From: James Smith <[REDACTED]>
Sent: 30 January 2026 11:52
To: Simon Davis
Cc: Cleo Jefferies; Darren Schofield
Subject: Pagham - RM Road - P/167/25/RES, P/177/25/DOC, and P/178/25/DOC

Following various comments on applications P/167/25/RES, P/177/25/DOC, and P/178/25/DOC, please see the below updates.

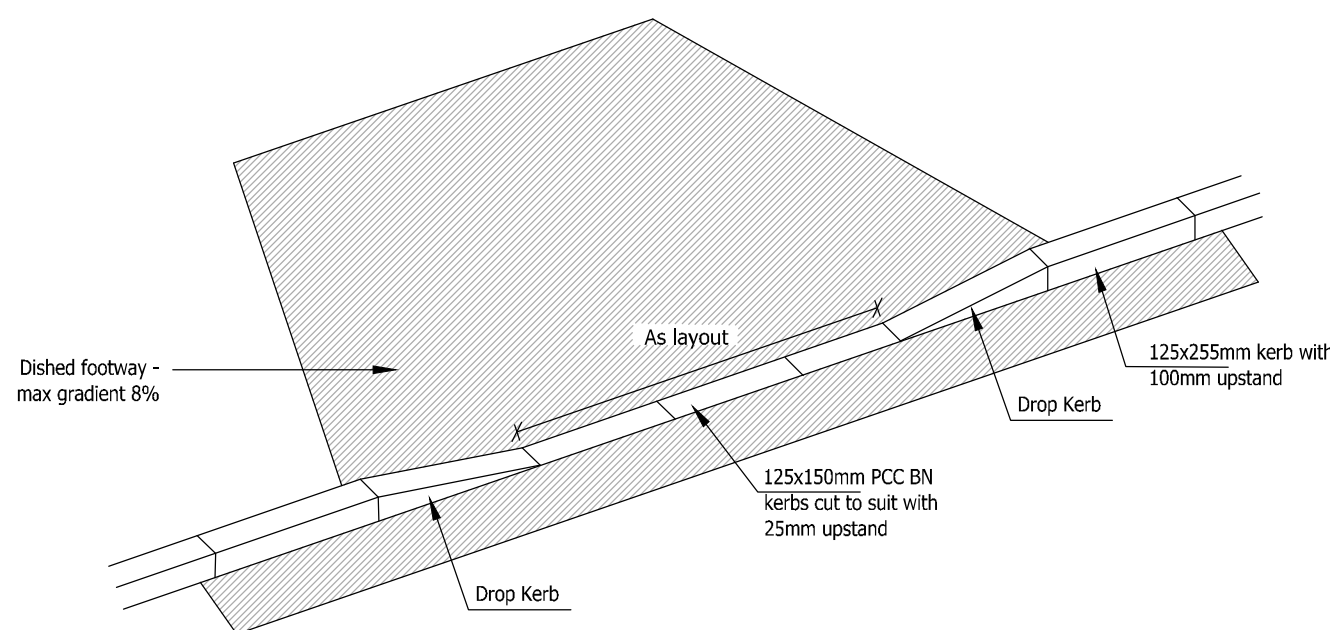
Plan/Document Name	Submitted No.	Revised No.	In P/167/25/RES	In P/177/25/DOC	In P/178/25/DOC	Relevant Update
Estate Road External Works Details	13226/1451 P1	13226/1451 C1				Inclusion of details surrounding self-setting gravel (as illustrated within the updated Estate Road External Works Layout plan).
Estate Road Main Drainage Details Sheet 1	13226/1551 P1	13226/1551 C1				No changes aside from now being a Construction Issue as opposed to the Initial Issue.
Estate Road Main Drainage Details Sheet 2	13226/1552 P1	13226/1552 C1				No changes aside from now being a Construction Issue as opposed to the Initial Issue.
Estate Road Drainage Layout	13226/1650 P7	13226/1650 C1				Access track annotation amended (to

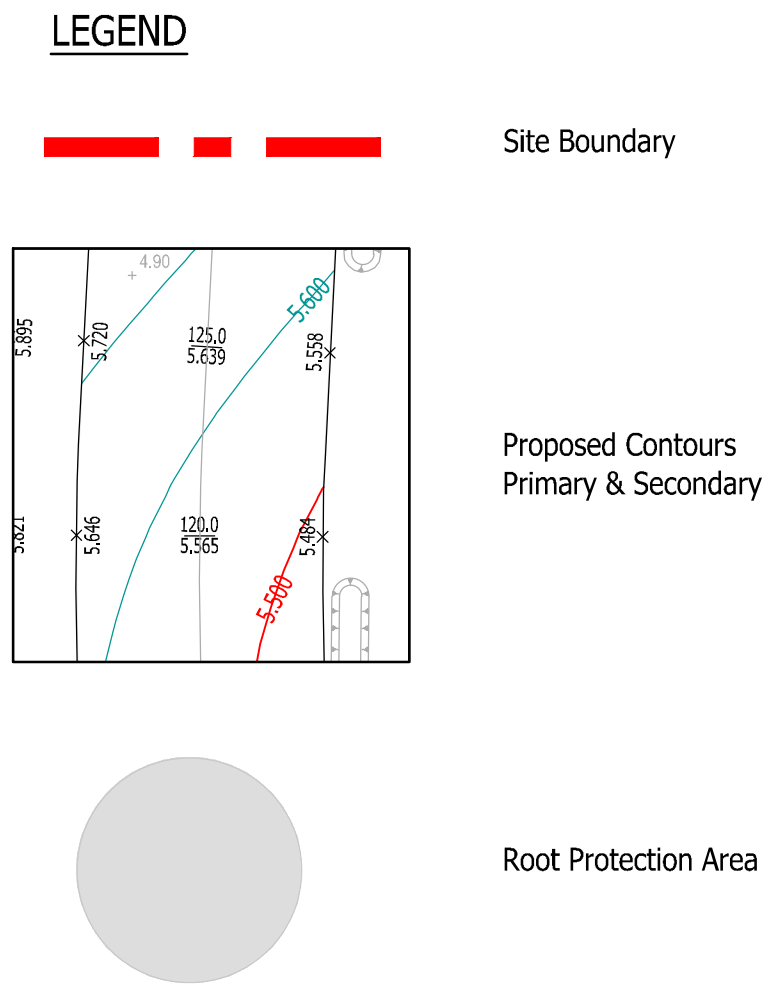
replace footpath annotation).
Estate Road Overland Flow Routes	13226/1655 P6	13226/1655 C1				Contour levels along the access track updated.
Estate Road Site Levels and Contours	13226/1851 P6	13226/1851 C1				Access track annotation amended (to replace footpath annotation). Contour levels along the access track updated. Proposed culverts are included along the access track.
Estate Road External Works Layout	13226/1861 P6	13226/1861 C2				Inclusion of highway sign locations and types. Inclusion of hatching along the access track illustrating the use of self-setting gravel (details provided in the updated Estate Road External Works Details).
Estate Road Refuse Vehicle Track Path Analysis	13226/1951 P6	13226/1951 C1				Proposed culverts are included along the access track.
Technical Note for Conditions 11-15	13226 Rev A	13226 Rev B				Appendix A provides the Construction Method Statement.
Soft Landscape Proposals	P02	P04				Proposed flowering sward mix updated to include the access track and proposed
